Boston Alternative Energy Facility

Statement of Common Ground between Alternative Use Boston Projects Limited and the Environment Agency

Planning Inspectorate Reference Number: EN010095

Date: ~~December 2021~~ February 2022

View 3: Photomontage view of the proposed Facility at Year 1 illustrating stack plumes at 'maximum' length (see notes below)

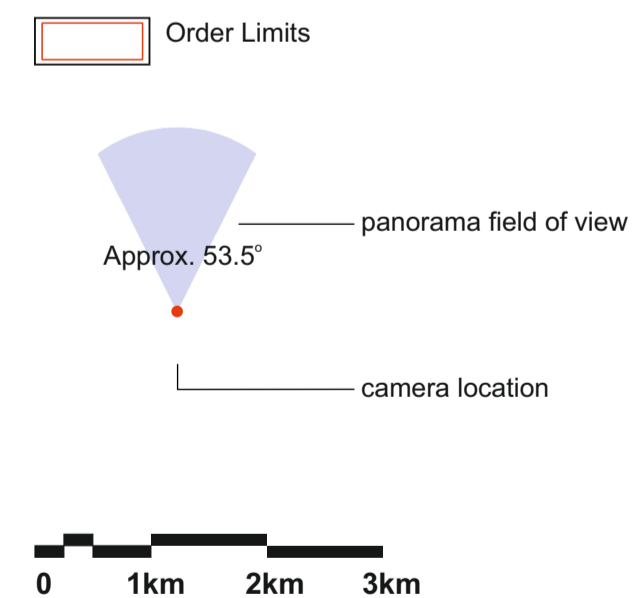
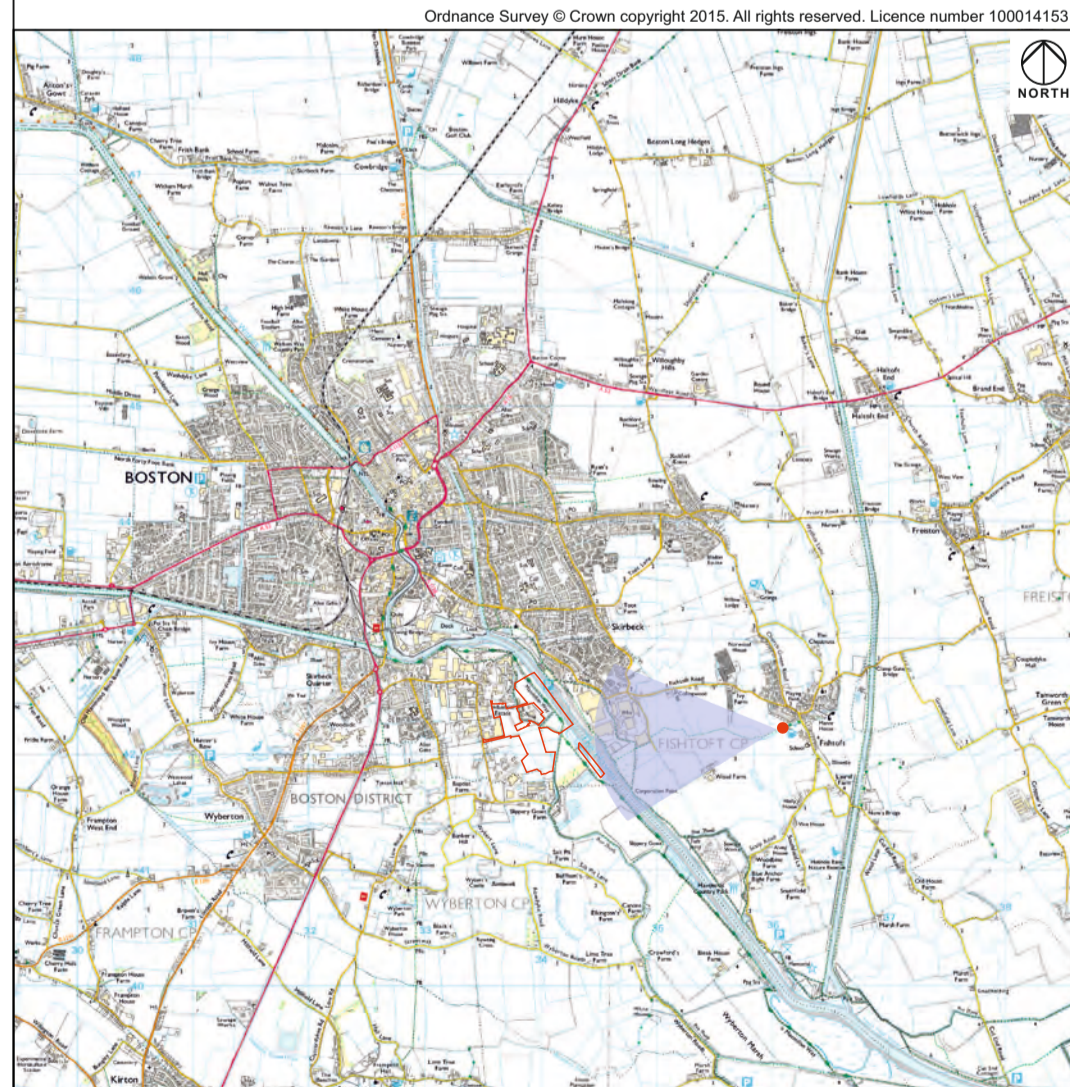
SoCG Reference	Document Reference	Topic	EA's Comment	AUBP Response	Status
EA 9.1	Chapter 9 Landscape and Visual Impact Assessment (document reference 6.2.9, APP-047)	Landscape and visual impact assessment	<p>The EA notes further information is needed on visible plumes.</p> <p>The EA notes a large visual impact on the landscape.</p> <p>The EA acknowledges that the information submitted is consistent with what it would expect to see from this type of process.</p>	<p>Further information on visible plumes was provided within documents submitted at Deadlines 1 and 2 including an updated Chapter 9 Landscape and Visual Impact Assessment (LVIA) (document reference 6.2.9(1), REP1-004) and Chapter 14 Air Quality (document reference 6.2.14, REP1-006) and updated photomontages (document reference 6.3.7(1), REP2-017 and document reference 6.3.9(1), REP2-019).</p> <p>The LVIA identifies significant, irreversible adverse visual effects upon certain visual receptors. Effects upon wider landscape character from visible plumes are lessened due to the existing baseline and presence of industrial and infrastructure features.</p>	Agreed
